Major Projects Team
Warragamba Dam Raising Proposal
Department of Planning, Industry and Environment
Locked Bag 5022
Parramatta NSW 2124

Objection to the proposed raising of the Warragamba Dam wall (SSI-8441)

Figure 3-2. Relative contribution different river catchments in range of Hawkesbury-Nepean Valley floods

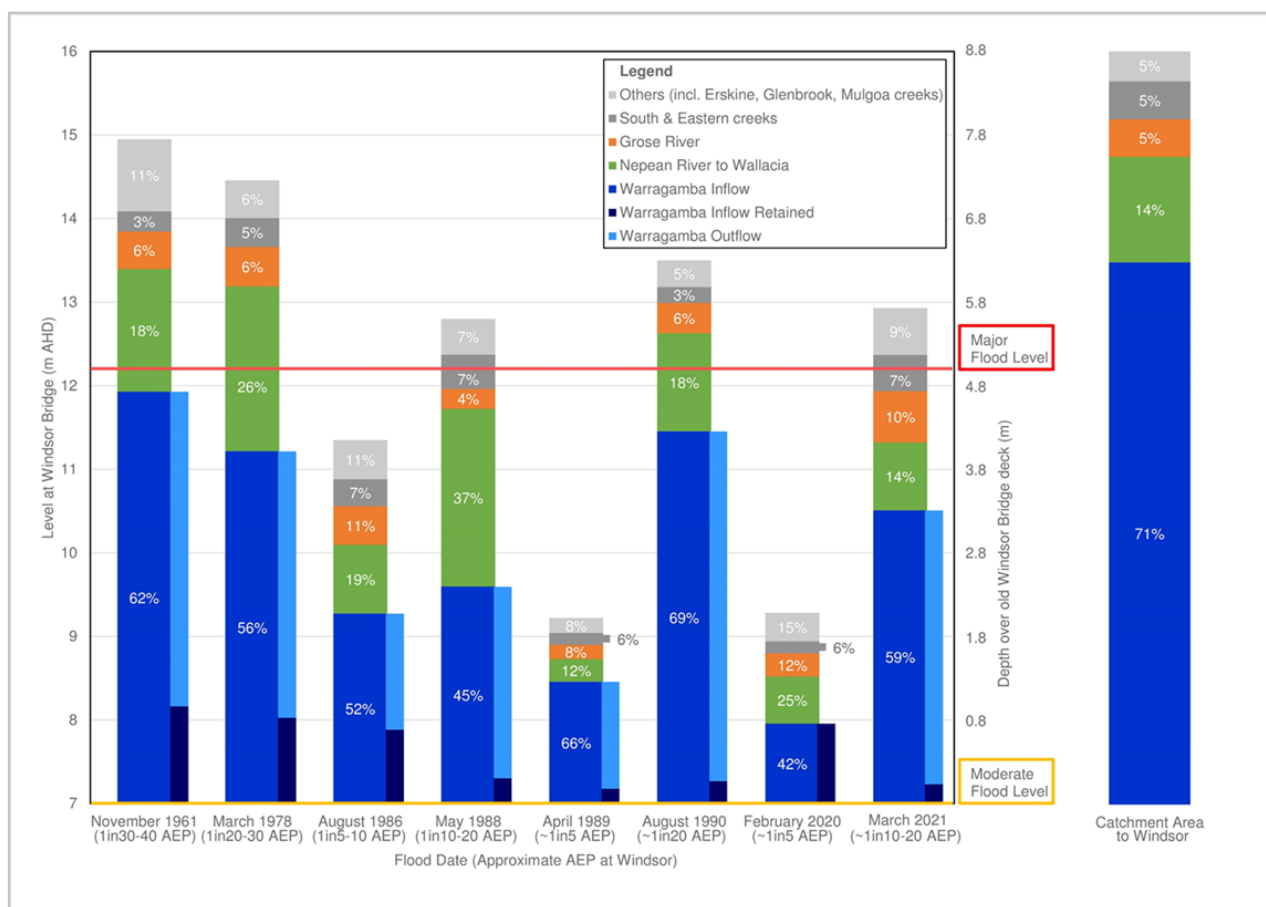
The EIS claims that ‘The large Warragamba Dam catchment historically contributes up to 70 percent of flows during flooding in the Hawkesbury-Nepean’ (see Figure 2 in the executive summary). This claim is misleading as it refers to **inflows** to the dam. Only outflows from the existing dam impact on flooding downstream, so the reference to 70 percent of flows during flooding is misleading.

The EIS narrative for Figure 2 should instead state that **outflows** from Warragamba Dam to have, on average, contributed slightly less than half of downstream floods (i.e. the light blue bars in Figure 2). In other words, providing additional flood mitigation by temporarily storing additional flood water behind Warragamba Dam over the World Heritage Area can only address half the floods. So, the proposed raising the dam wall can only be a half-measure.

Only the light blue bars showing Warragamba dam's outflows to downstream floods are relevant to the analysis of relative contributions from catchments (inflow-retained waters).
